CITY OF ALBUQUERQUE

June 1, 2017

2400 Marie Park

Re: Drainage Control Ordinance (14-5-2-1) Violations for Erosion and Sediment Control

Erosion Sediment Control Plan

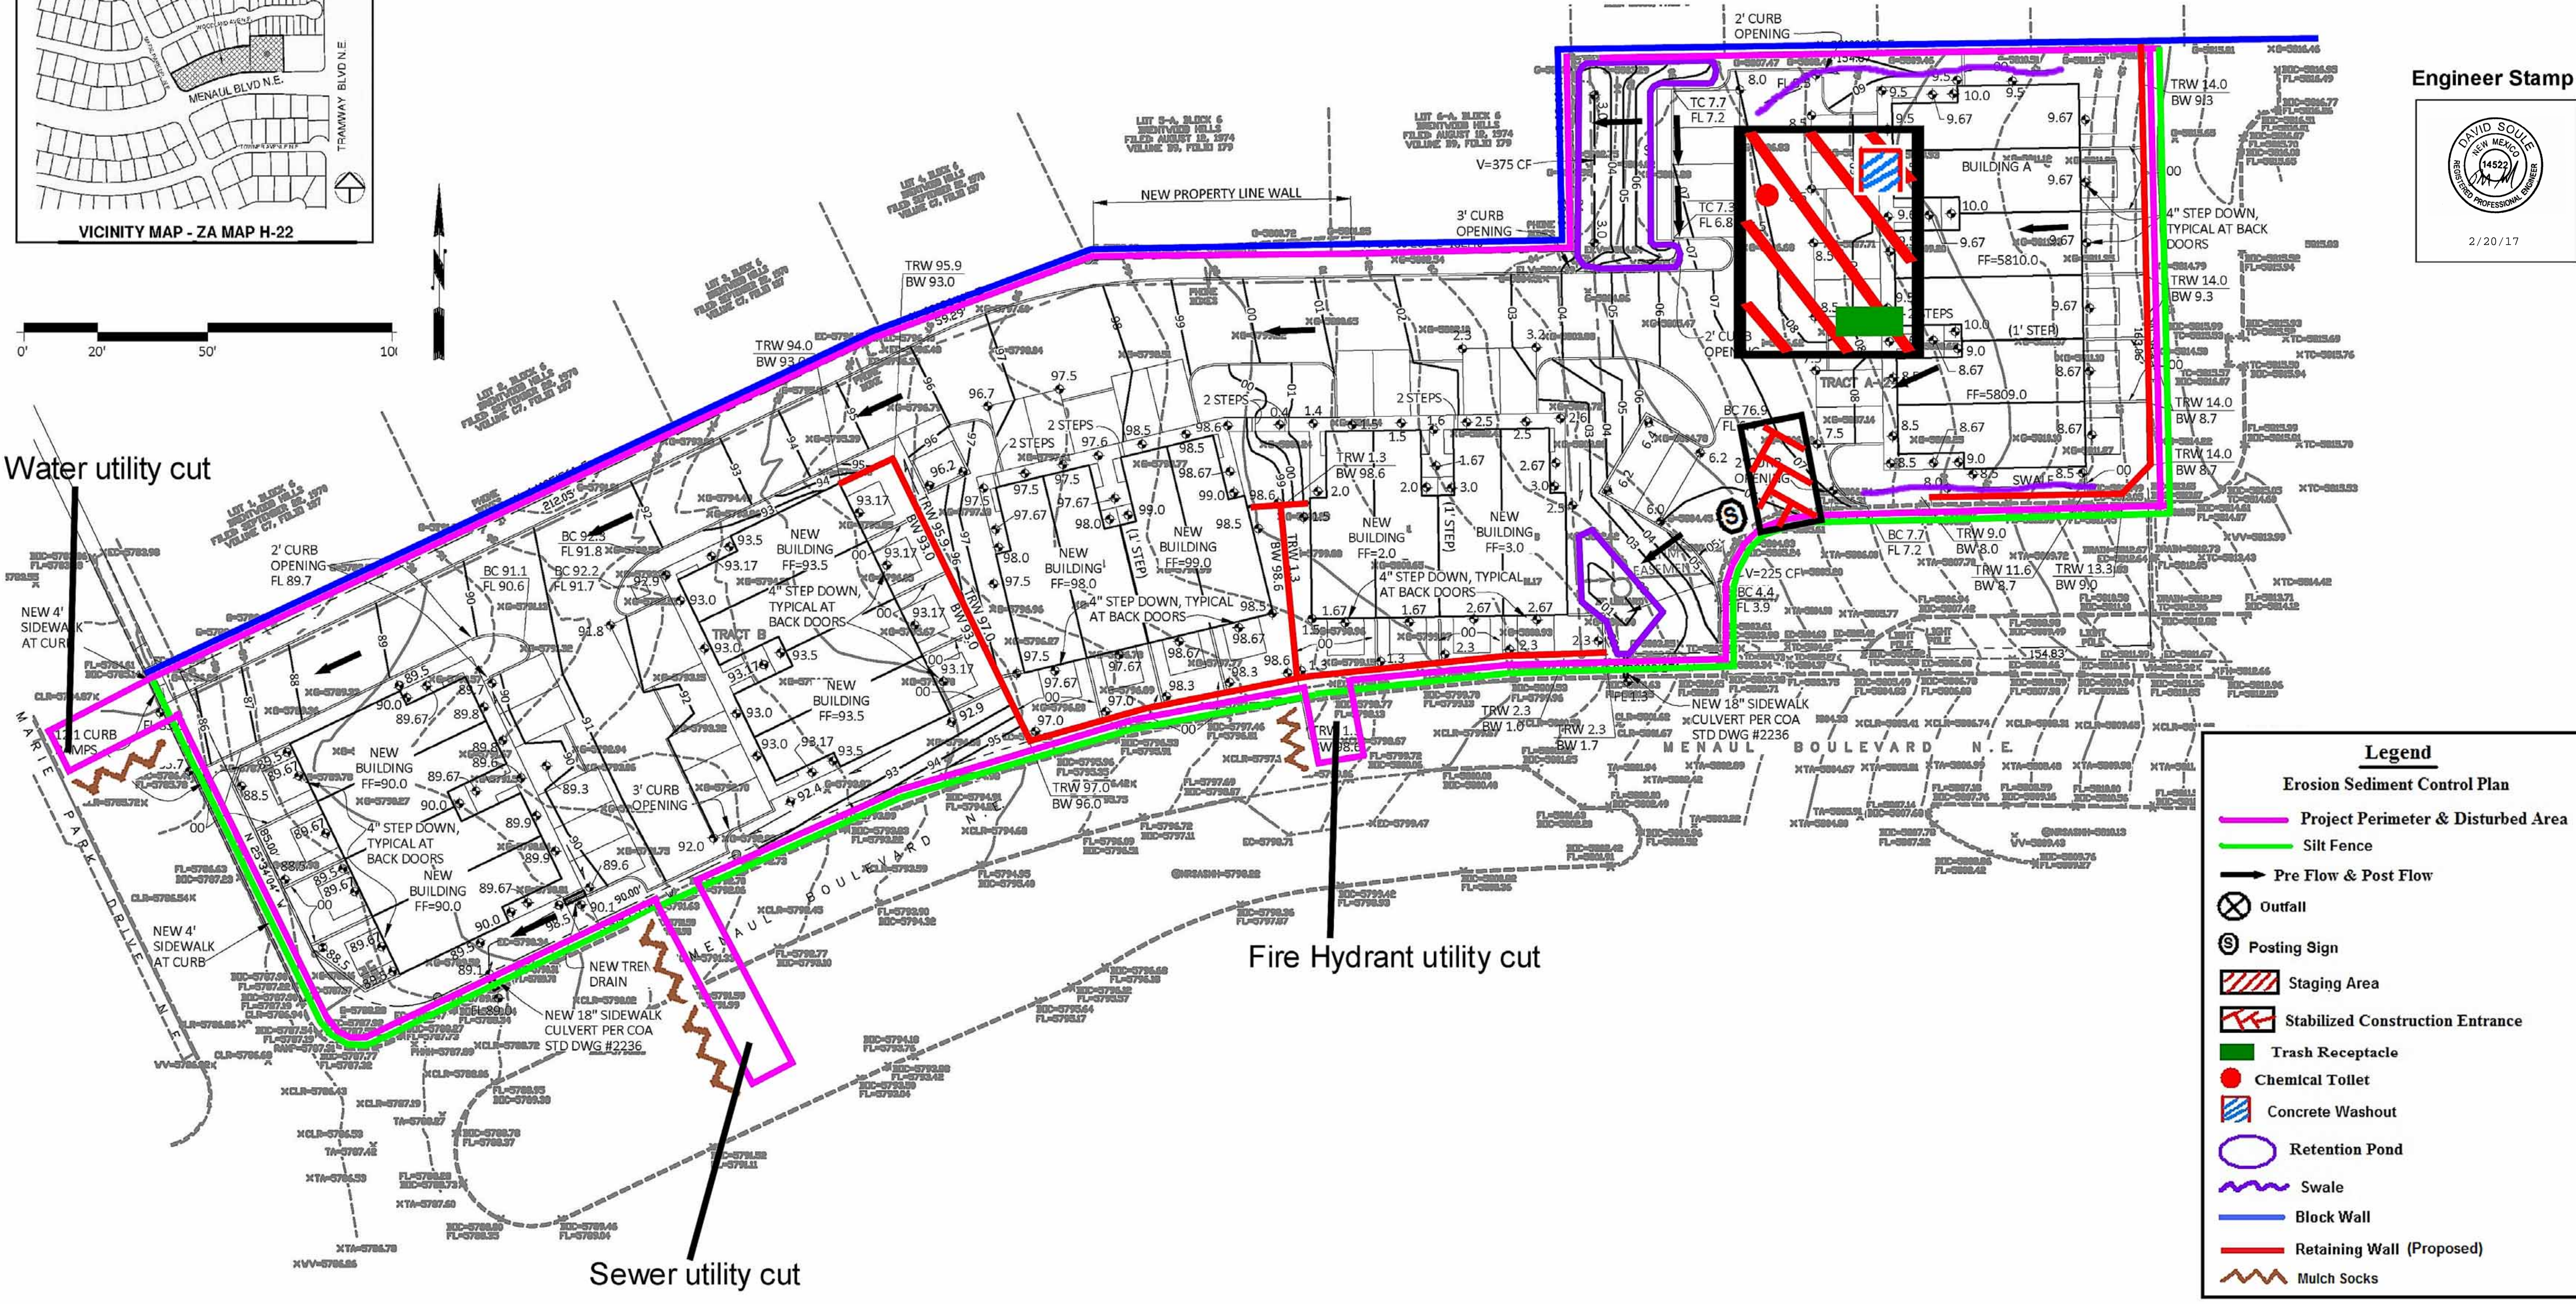
1. The silt fence was not installed along Marie Park Dr.
2. Silt fence was not installed from Marie Park Dr. to the wall shown in the last photo.
3. Sediment was observed in Marie Park Dr due to lack of sediment BMP/silt fence.
4. A large dirt ramp was placed in the street.
5. Cement pollution in the soil.
6. An acceptable concrete wash-out facility was not observed.
7. Silt fence and dirt covering a portion of the public sidewalk.

No sediment BMP/silt fence.

No sediment BMP and large dirt ramp in the street.

Cement pollution.

Silt fence and dirt on public sidewalk.

1. Remove sediment from Marie Park.
2. Install a sediment BMP/silt fence along Marie Park Dr.
3. Install silt fence in the northwest corner from Marie Park Dr to the wall.
4. Remove dirt ramp from the street and use approved access point.

1. Remove cement pollution.
2. Have an acceptable concrete wash-out facility on site and use it.
3. Remove silt fence and dirt form public sidewalk on Menaul Blvd.
